**Examining Authority's
First Written Questions**
Abergelli Power Project

PINS REFERENCE: EN010069
CCS EXAMINATION REFERENCE: 20011204
CCS APPLICATION REFERENCE: 2018/1289/DCO

The Examining Authority's written questions and requests for information (ExQ1)

Issued on 17 October 2018

HEDGEROW PLAN

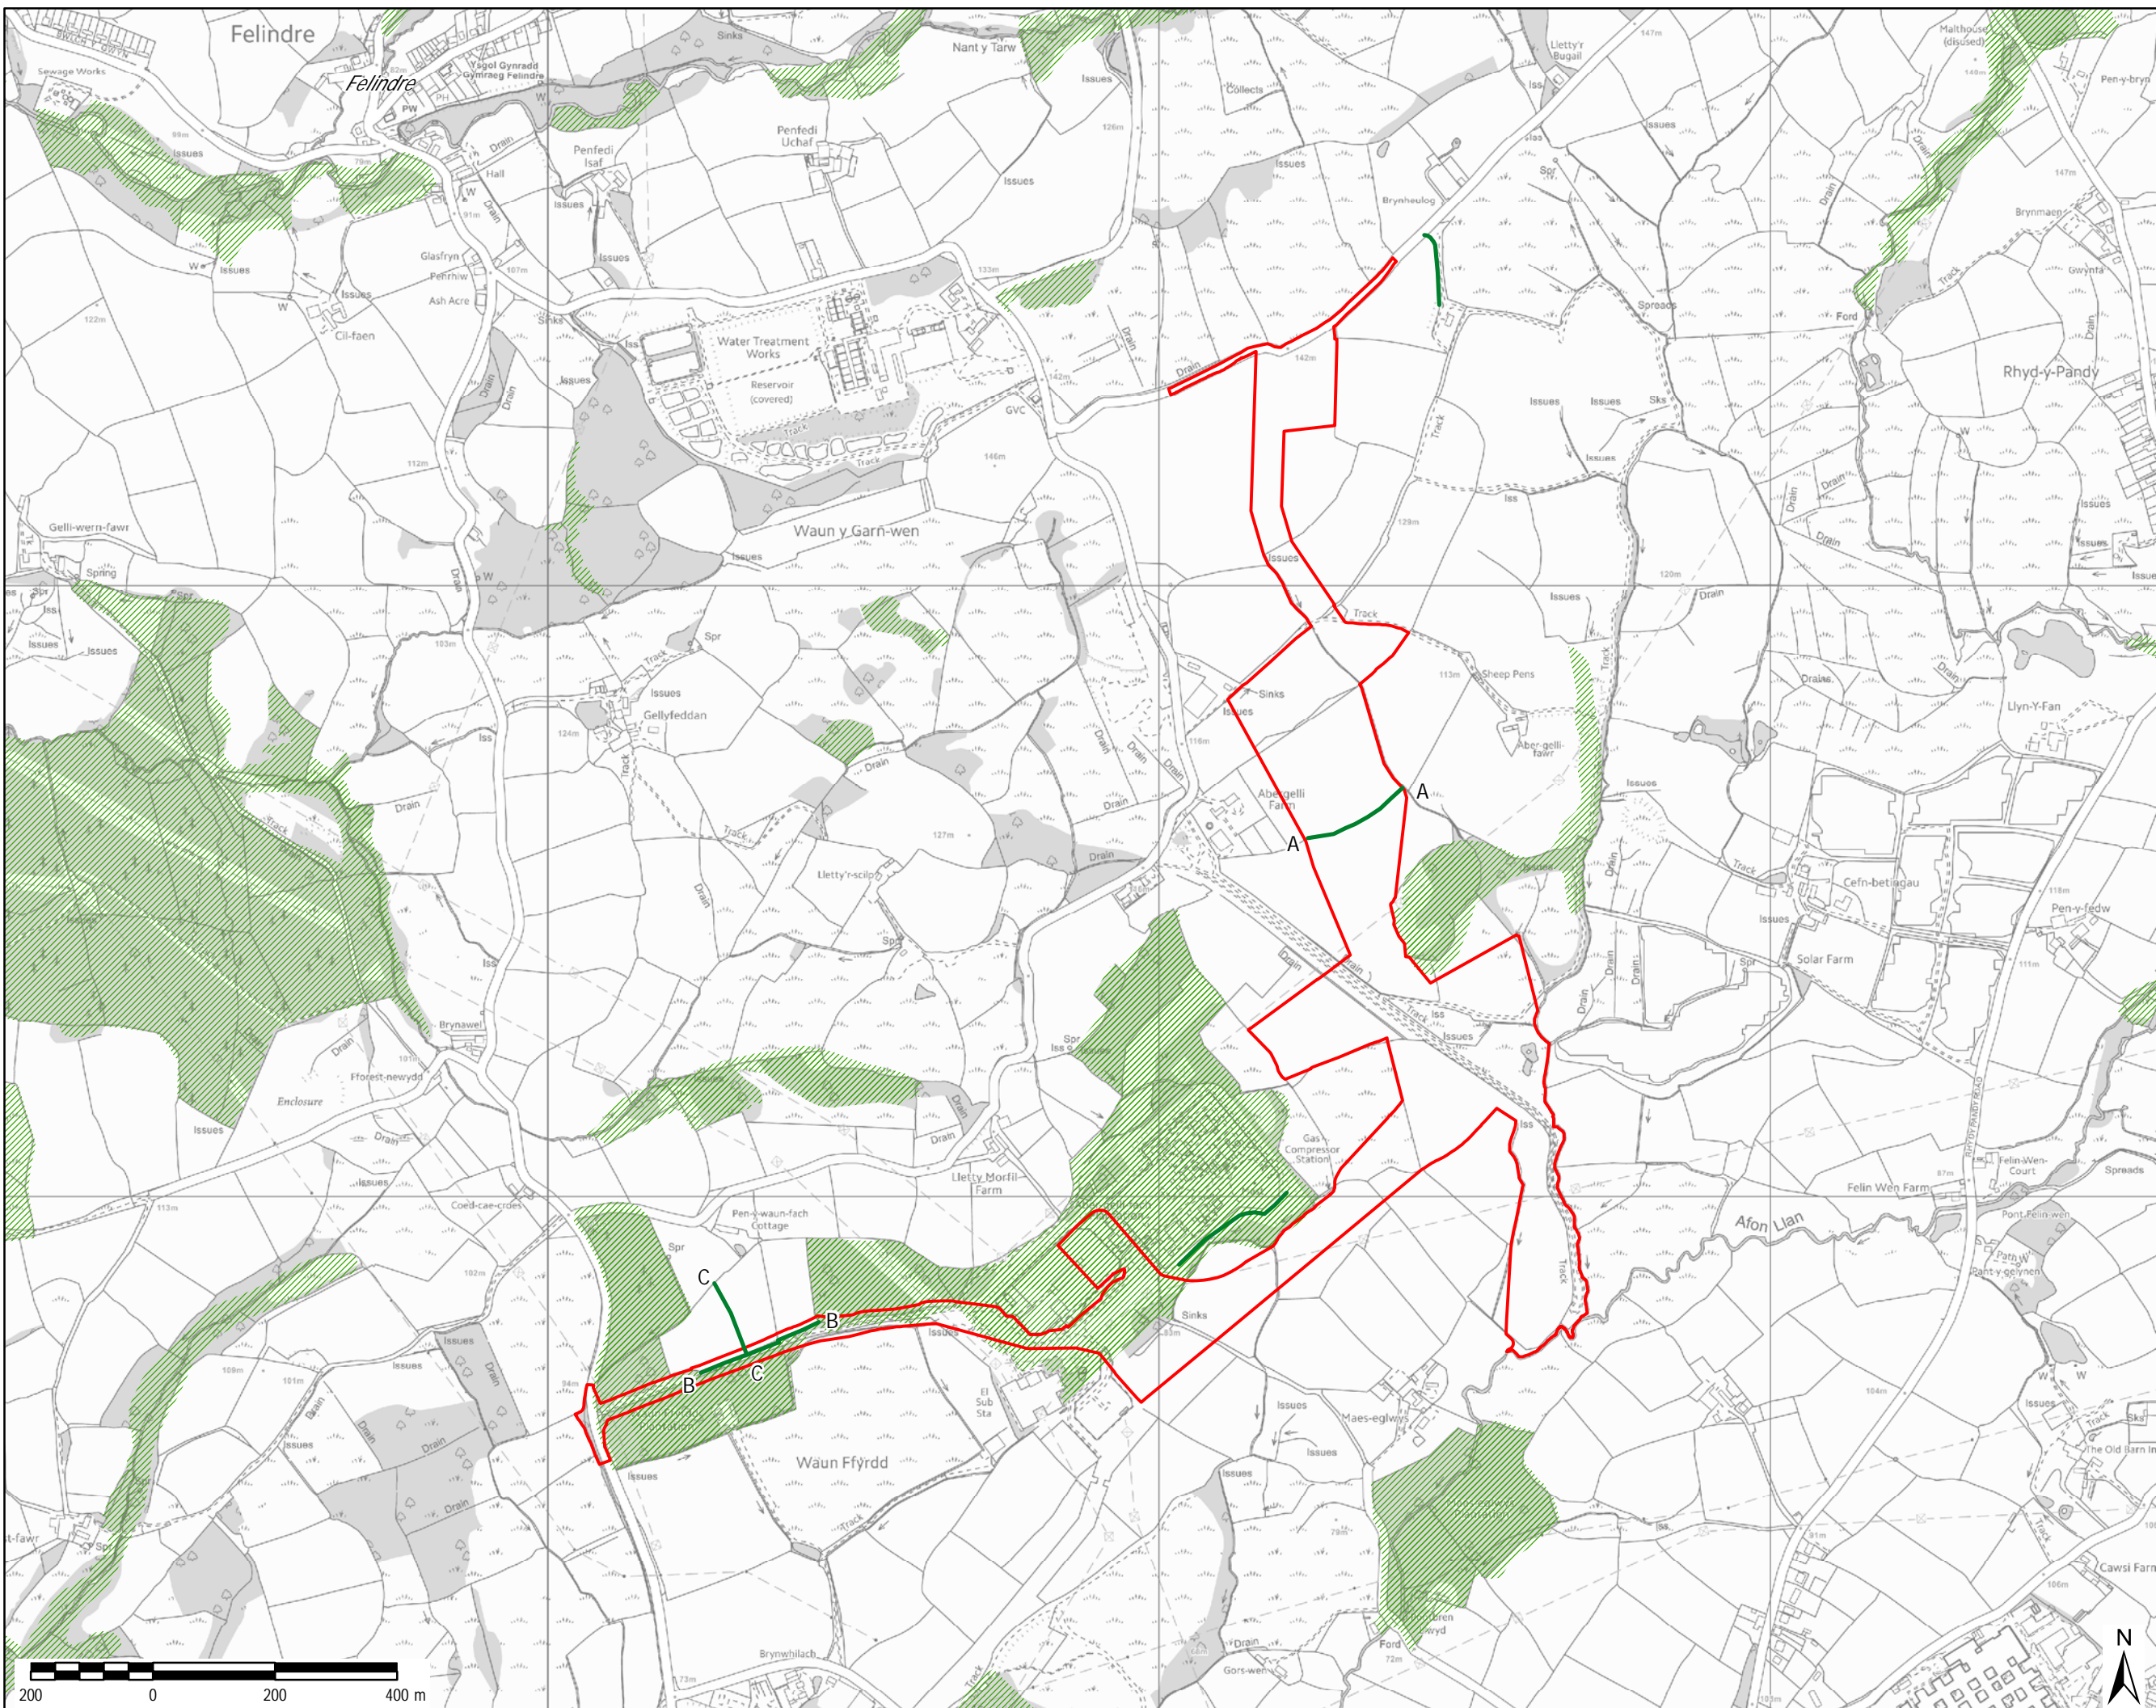
1.6.	Biodiversity, Ecology and Natural Environment (including HRA)	
1.6.5.	<p>Trees and hedgerows:</p> <p>At paragraph 2.11.63 of the ES [APP-042] it states:</p> <p><i>“Draft Policy ER 11 states that “development that would adversely affect trees, woodlands and hedgerows of public amenity, natural/cultural heritage value, or that provide important ecosystem services will not normally be permitted.”</i></p> <p>How does the Applicant believe it conforms with draft policy ER 11?</p> <p>What is the view of CCS?</p>	<p>The development area will require the removal of some trees, these are outside of the areas of identified ancient woodland shown on the Lle web pages.</p> <p>The embedded mitigation stated is for all retained trees to be protected from any damage. There will be permanent loss of broad-leaved semi-natural woodland, broadleaved plantation woodland and species poor hedgerow habitat. Some of this loss will reduce connectivity across the site and wider landscape. This is significant so requires additional mitigation.</p> <p>The loss of trees from the hedgerows and from the apparatus site can be adequately mitigated on site by planting trees.</p> <p>The landscape ecosystem services provided by the sparse, unconnected woodland planting and native tree planting outlined in Fig 3.6c is much less beneficial than planting in a large block of woodland or linking the two proposed woodland areas to provide foraging and other habitat connectivity. Much greater detail of the species mix and full planting specification (to include sizes and density) is required to be submitted. A species diverse mixture would be required but this would also ensure a problem affecting one genera/species does not have a large impact on the overall integrity of the landscaping.</p>
